**Project Name:** \* Bridge 9 over South River on US 13

Subject: **Request for Additional Information for T.I.P. B-4635 (Replacement of Bridge 9 over South River Overflow on US 13, Sampson County)**

Below are responses to needed additional information and corrections to previously submitted items for the permit application for B-4635 (Replacement of Bridge 9 over South River Overflow on US 13, Sampson County)

MATCH TO SHEET 4 -L- STA. 21+50.00

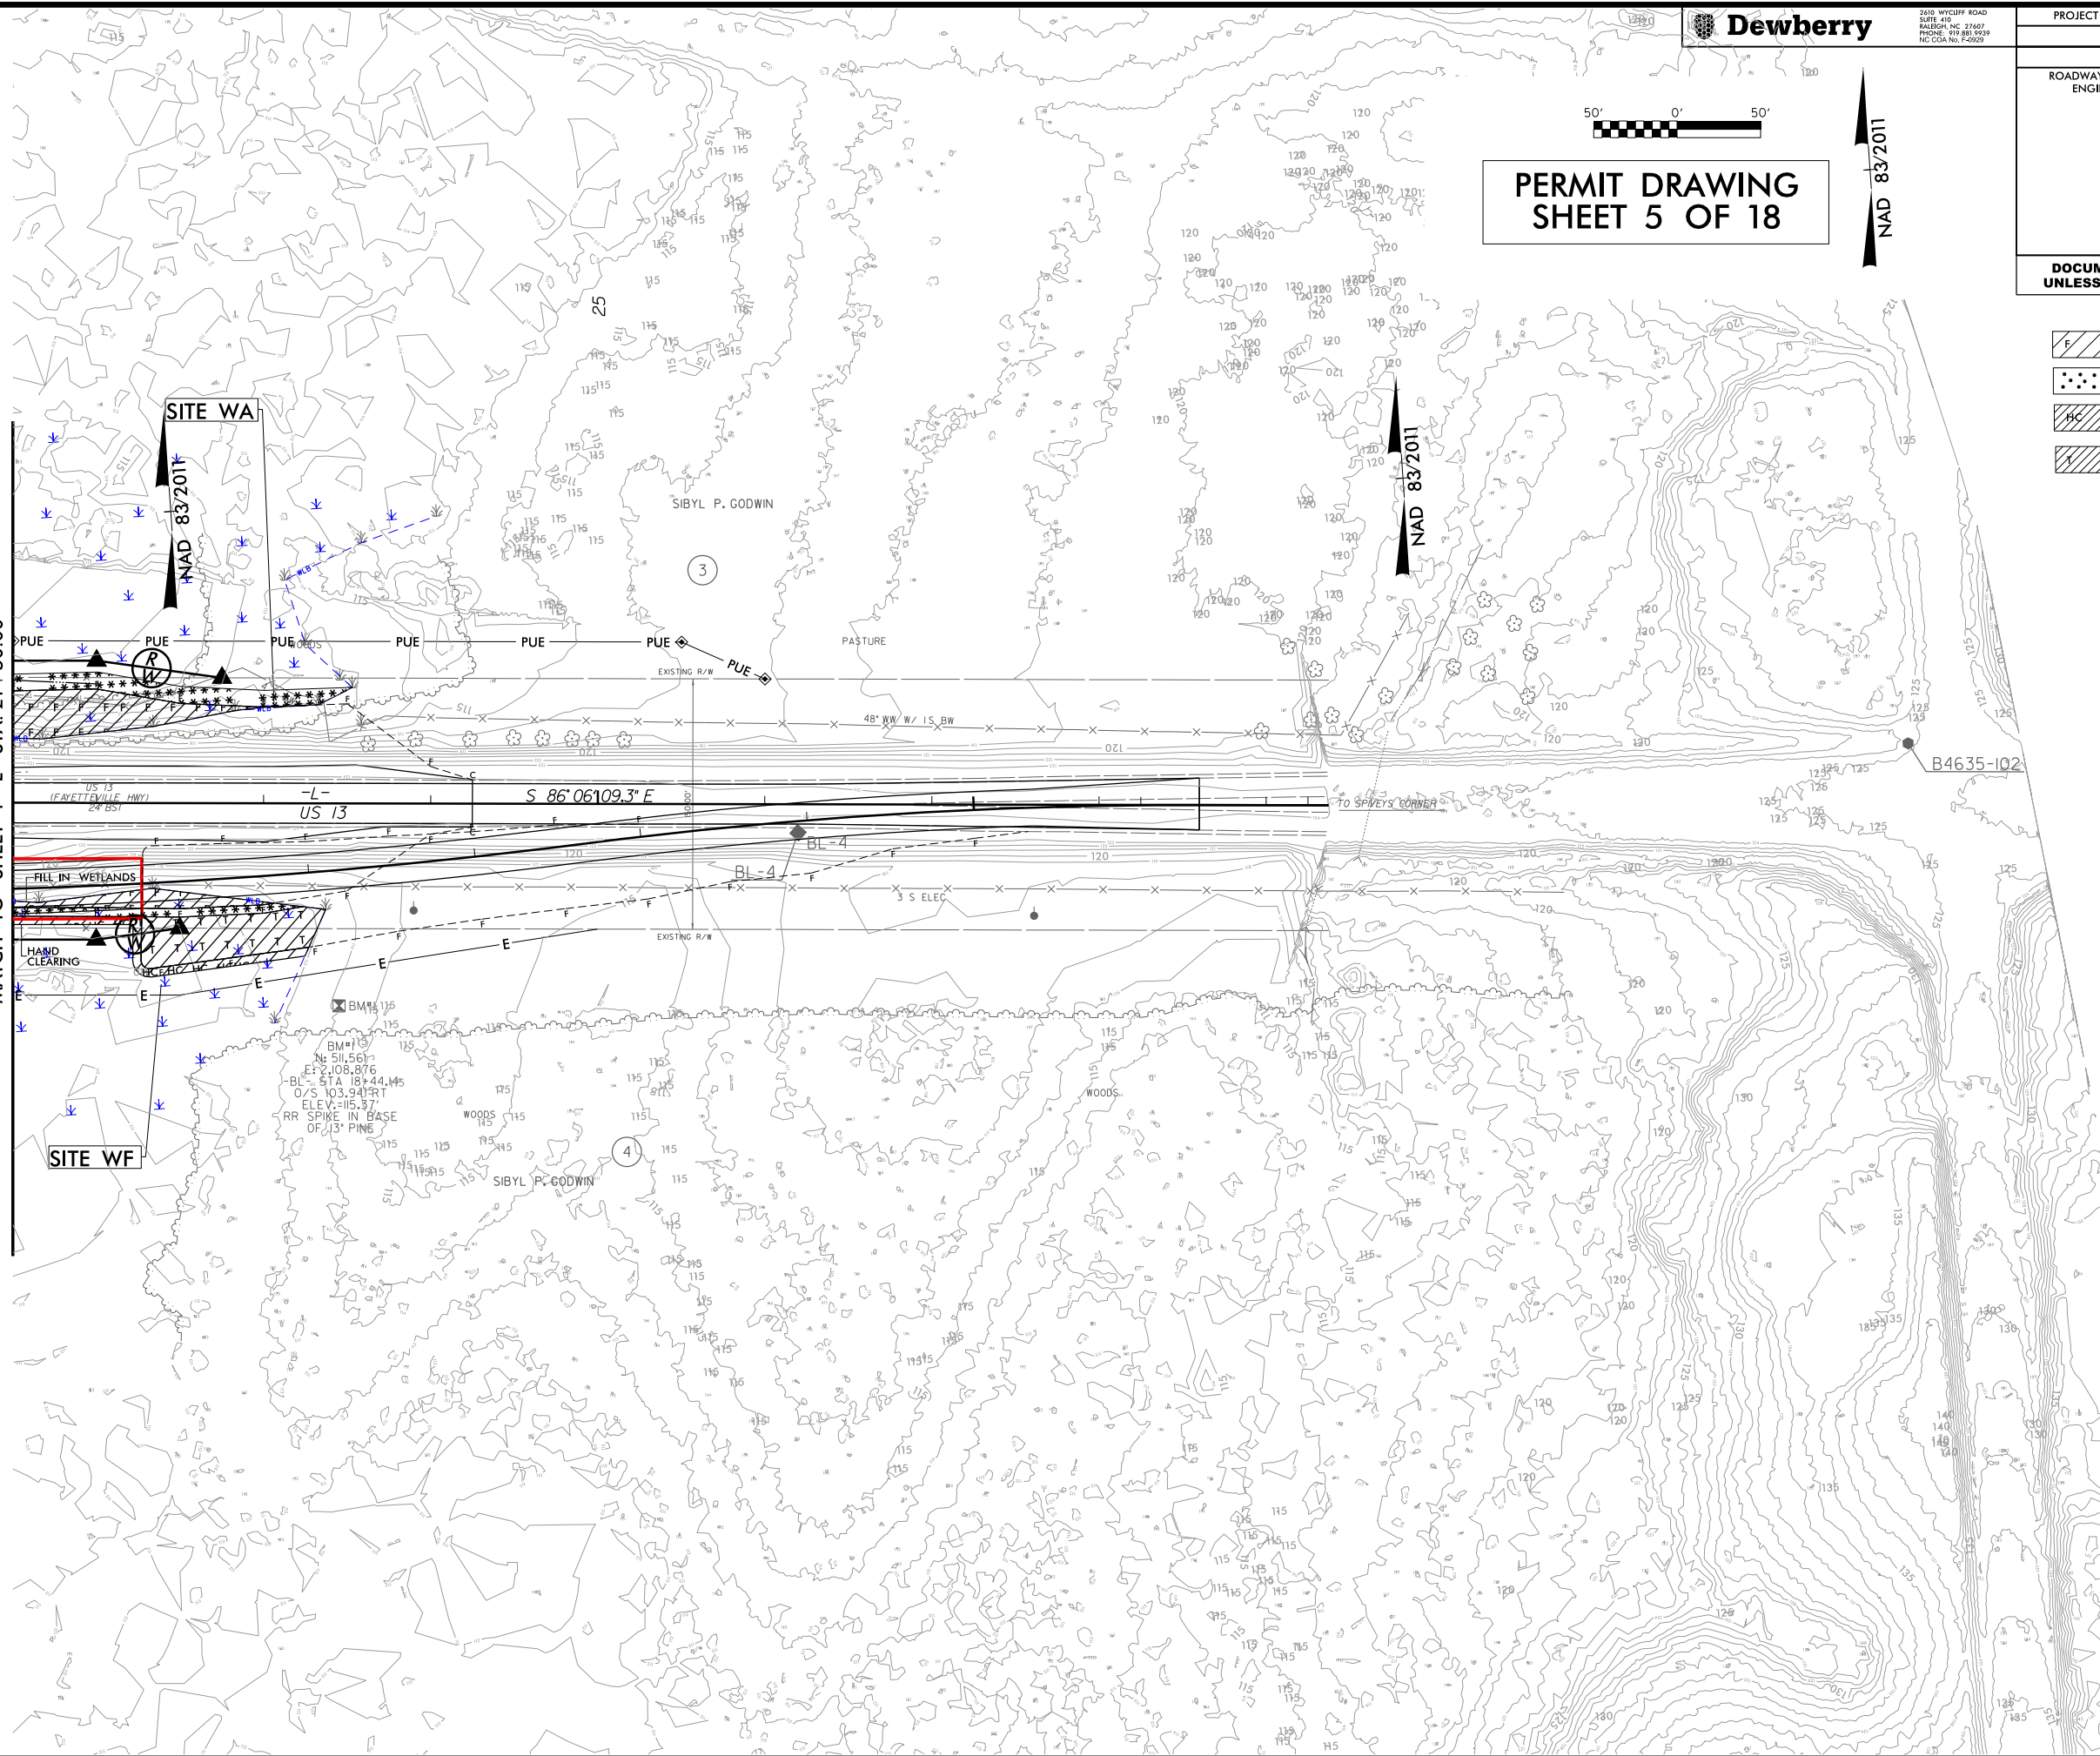
- along the north side of the project where permanent fill is called for HC is noted. Within Division 3, MC has always been requested along the slopes of permanent fill. This has been confirmed with Division please correct throughout the package. If less than 10' of fill 5' of MC is appropriate and greater than a 10' fill height 10' has been the standard. **Permit drawings have been revised.**

PERMIT DRAWING
SHEET 15 OF 18

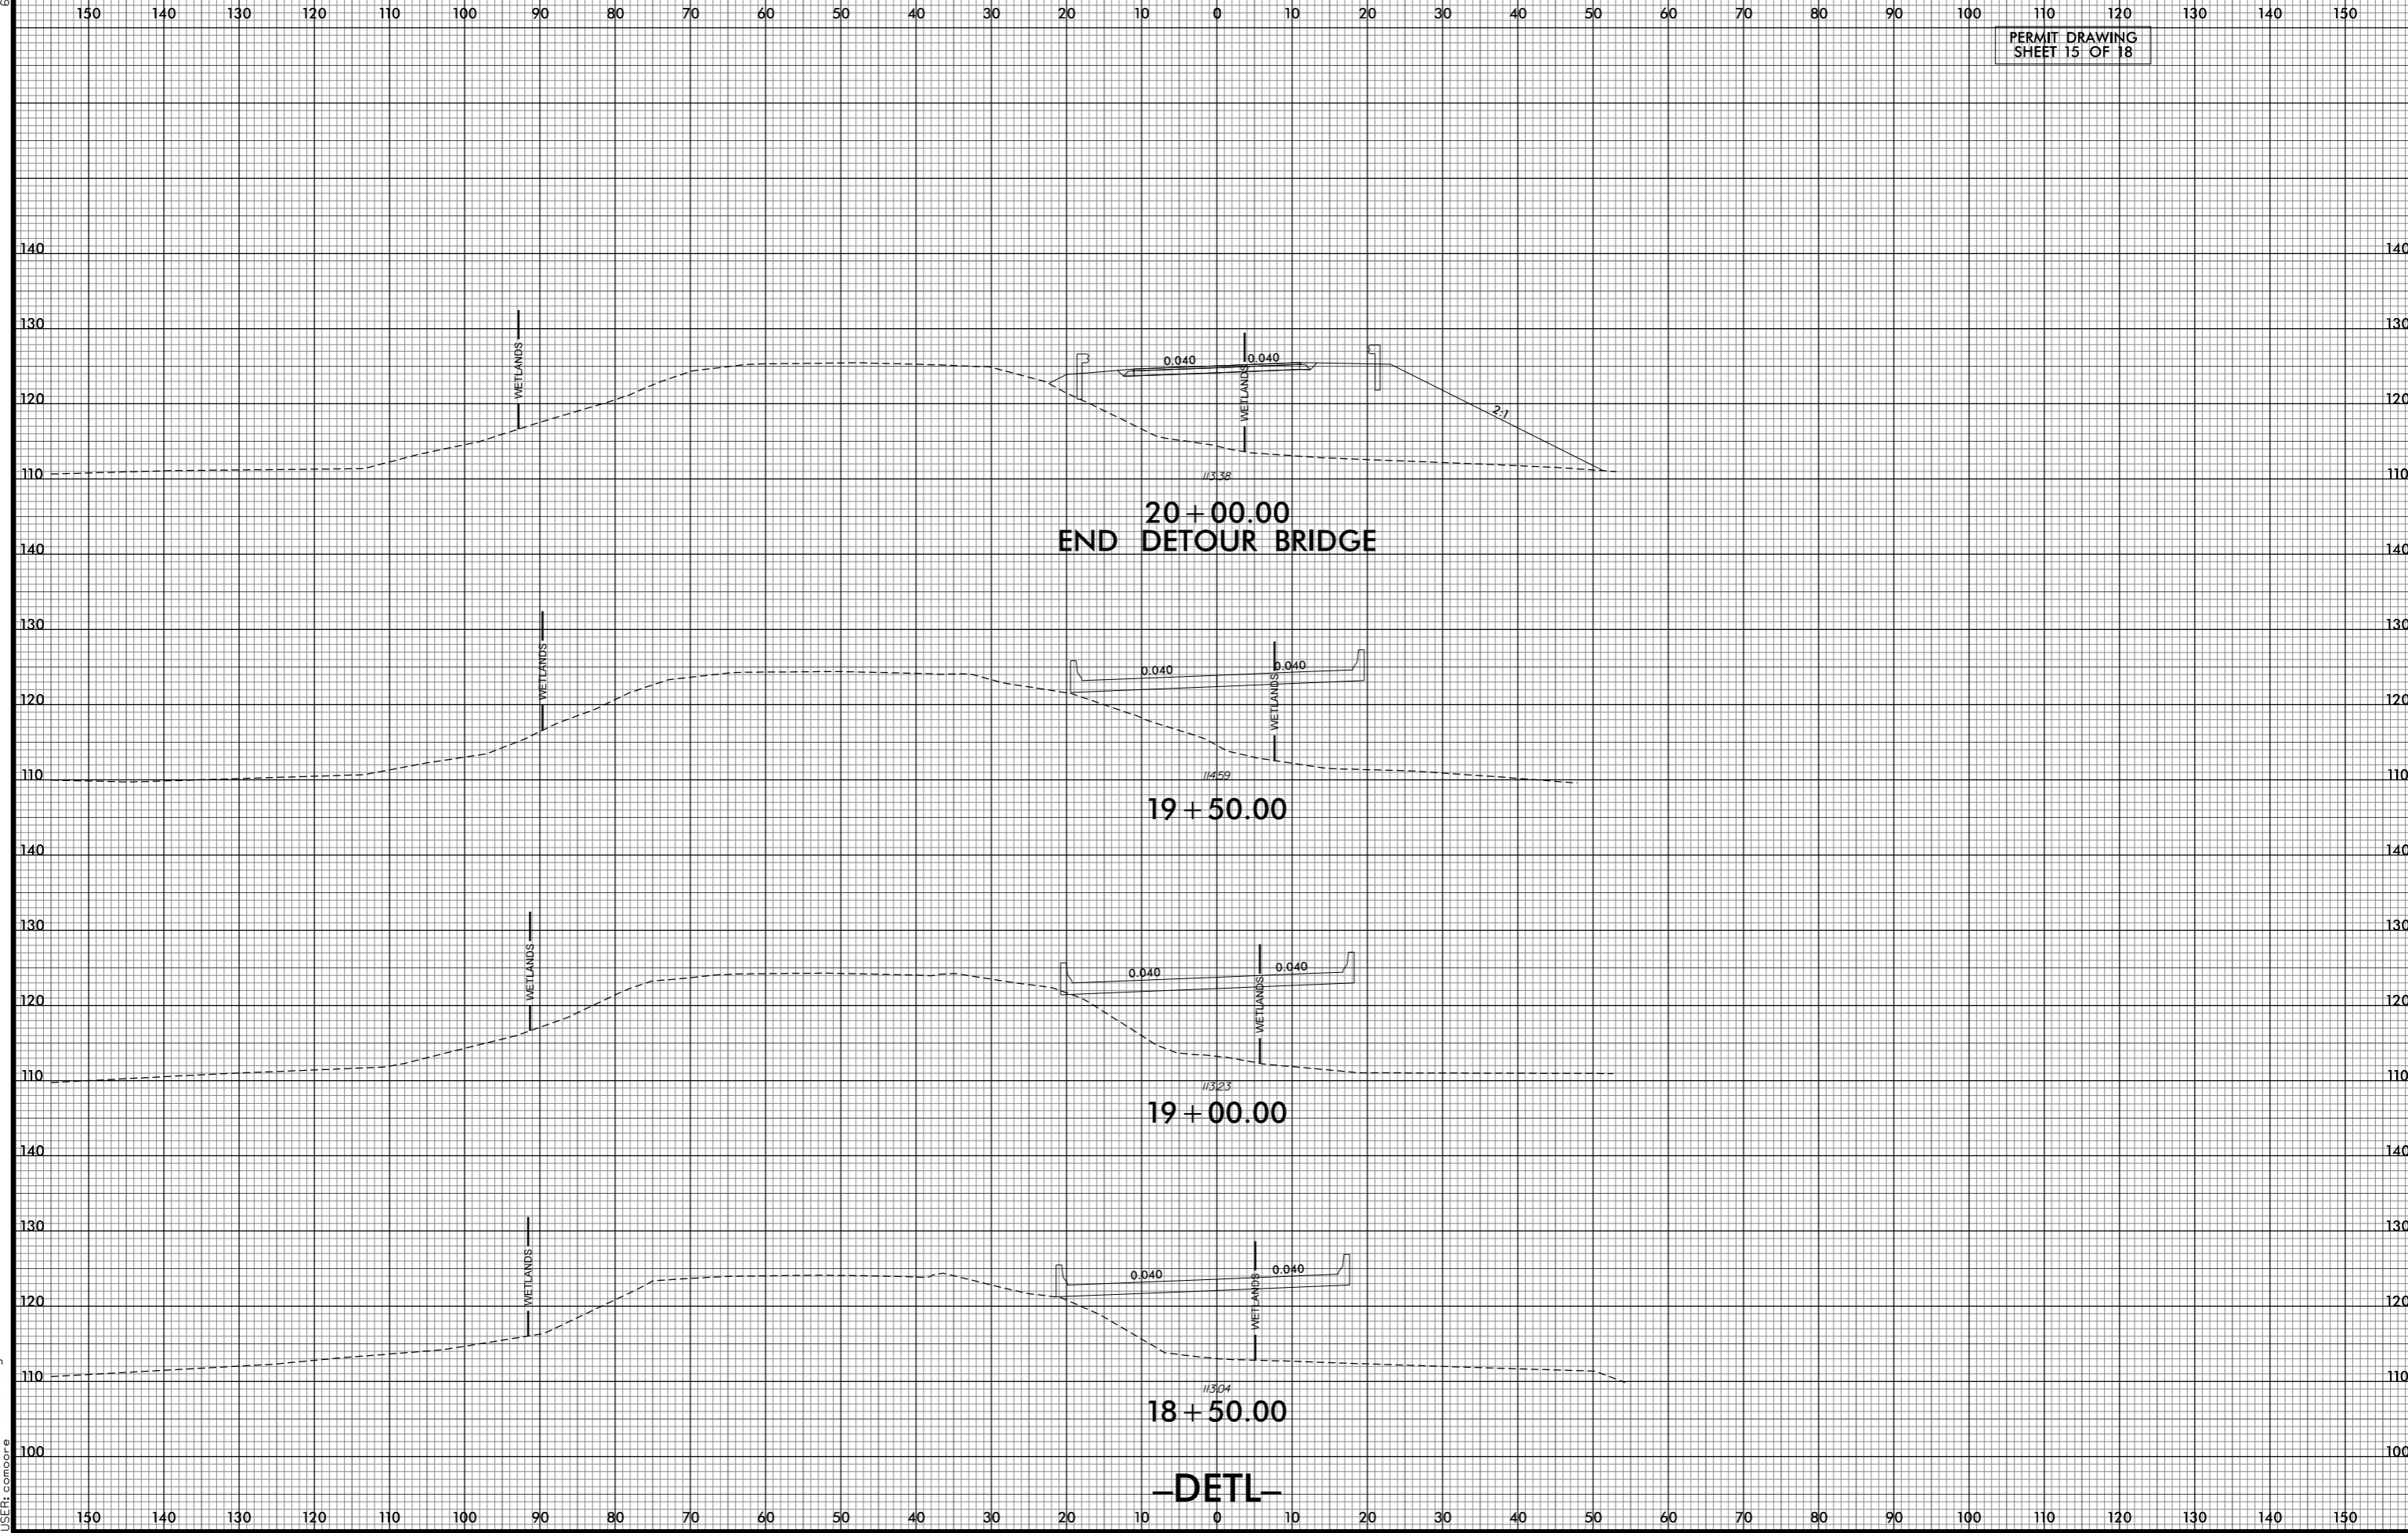
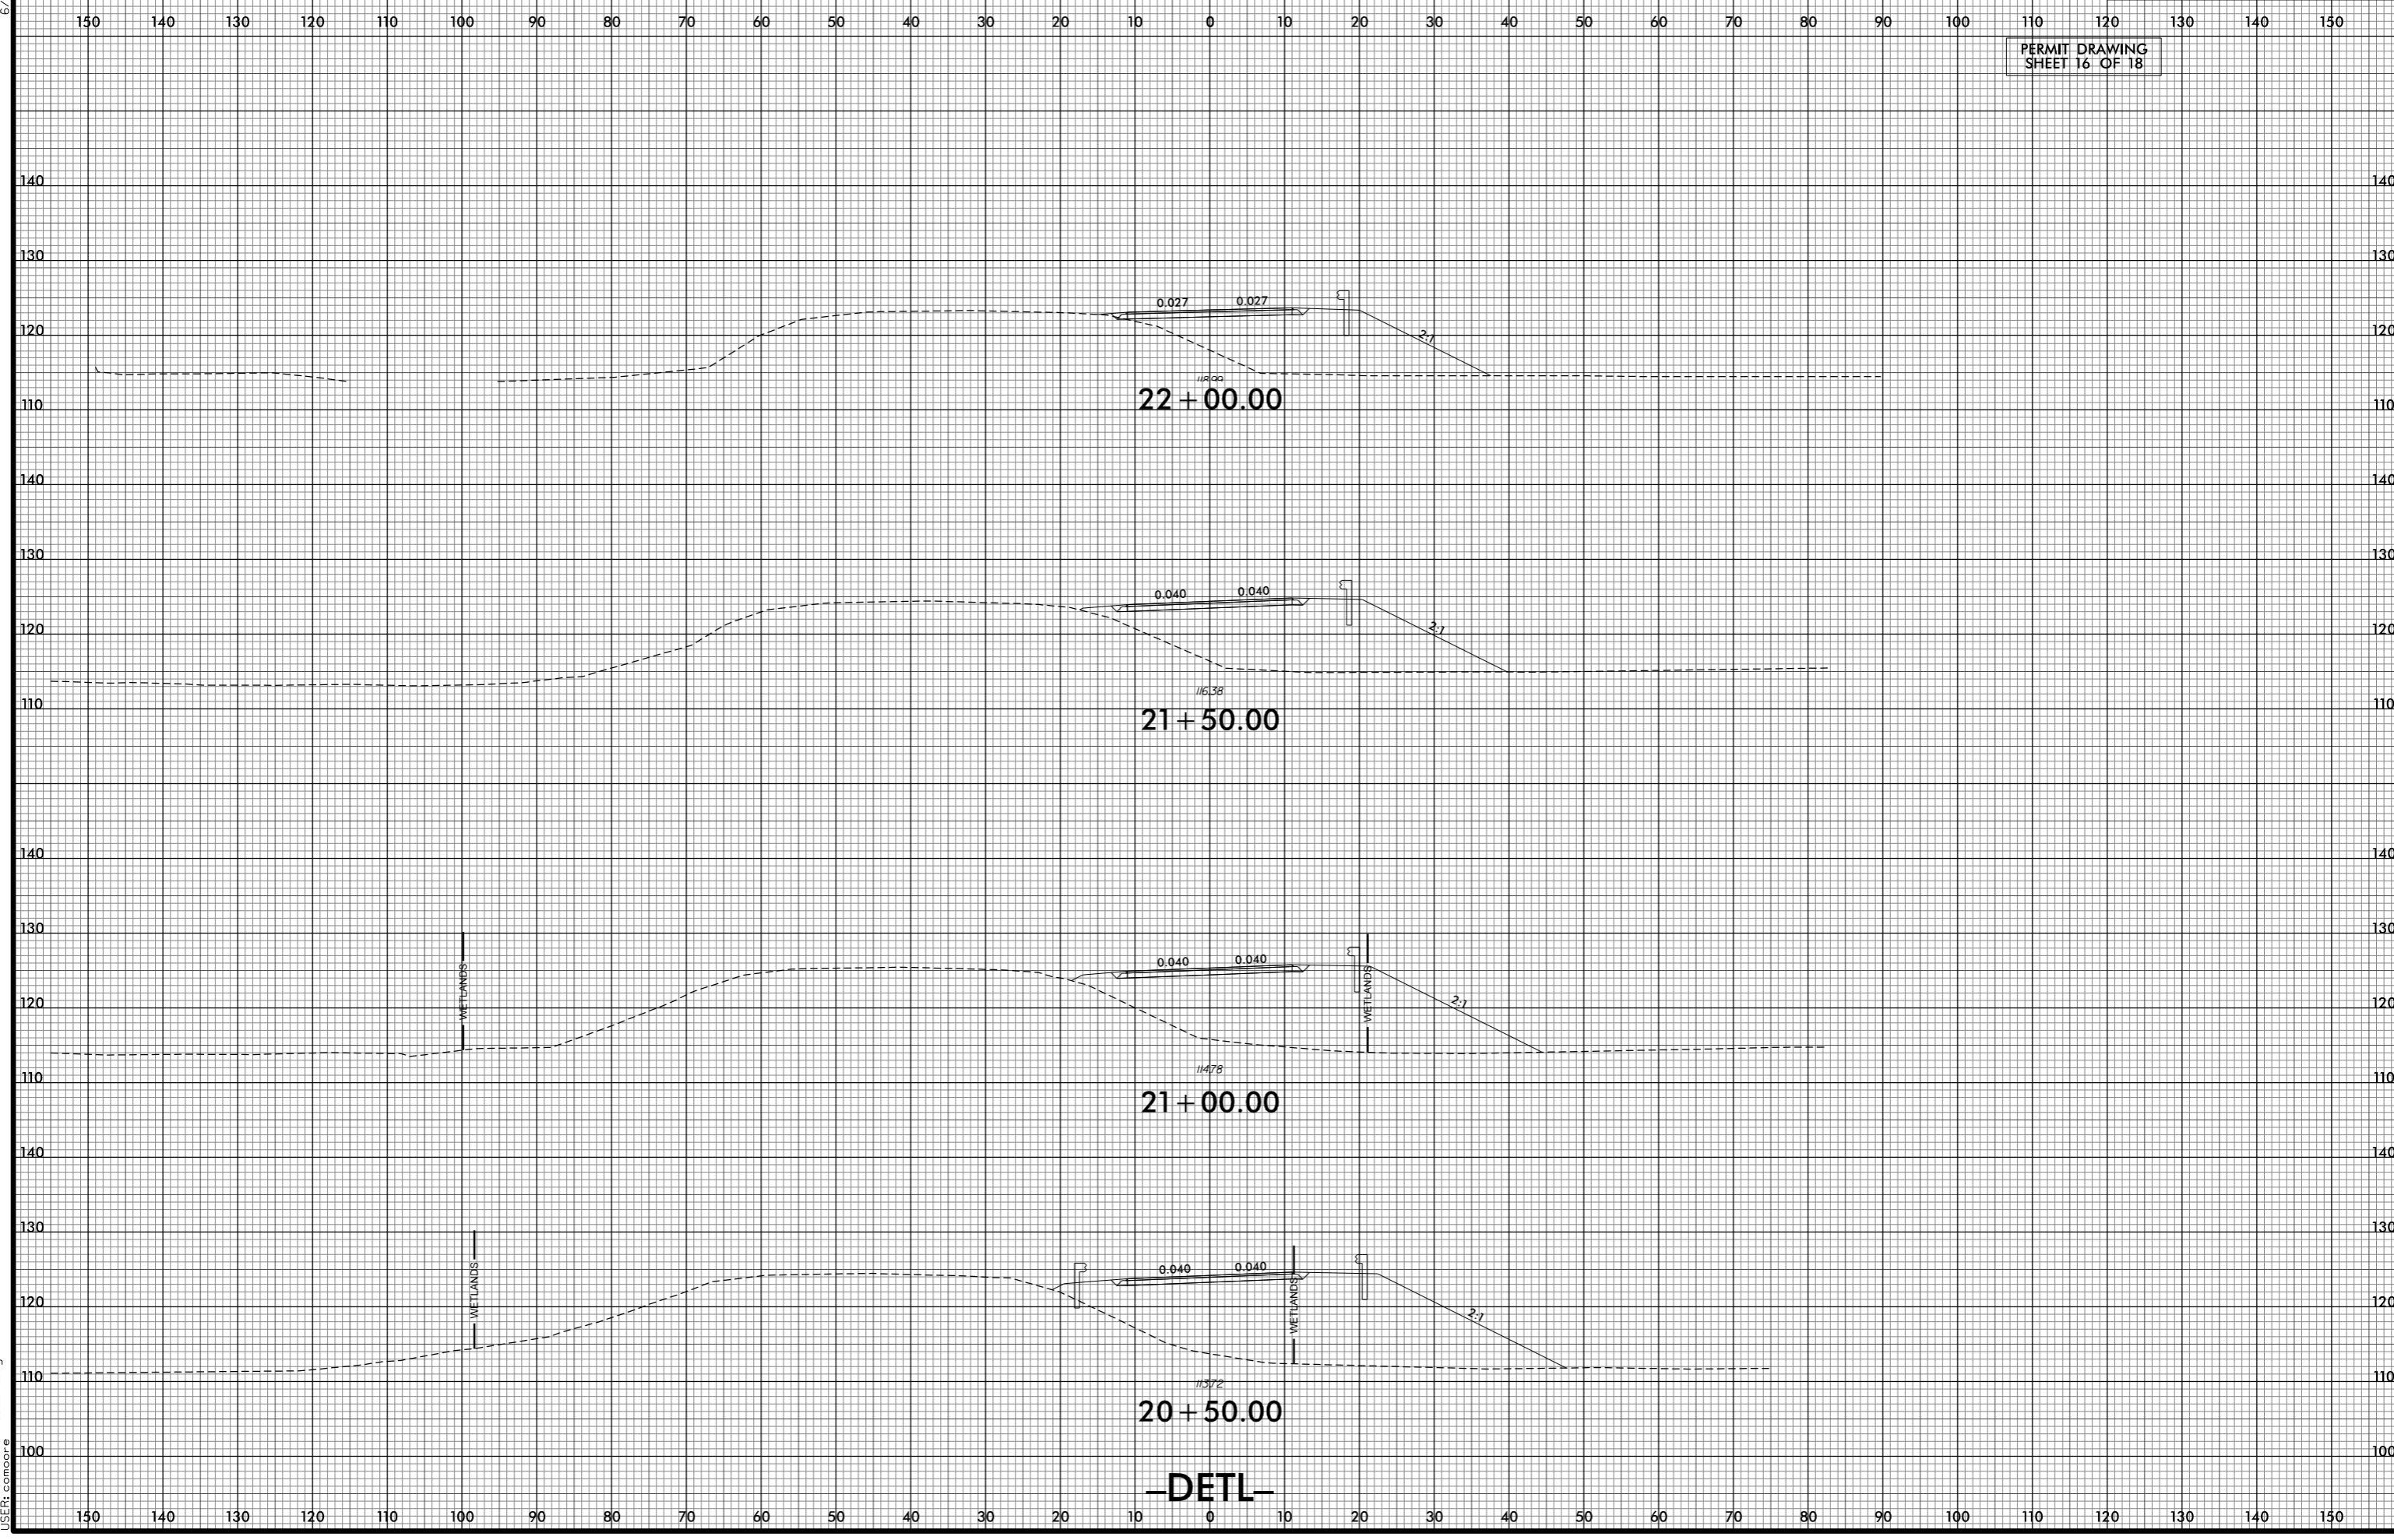
-there is no slope listed in the cross section drawings regarding the temp detour which leads to the question, could the slope be steeper than 3:1 since it would most likely be constructed with a rock base thus reducing the amount of temporary impact? **Cross sections of the detour are included in revised drawings to show 2:1 slopes along the detour.**
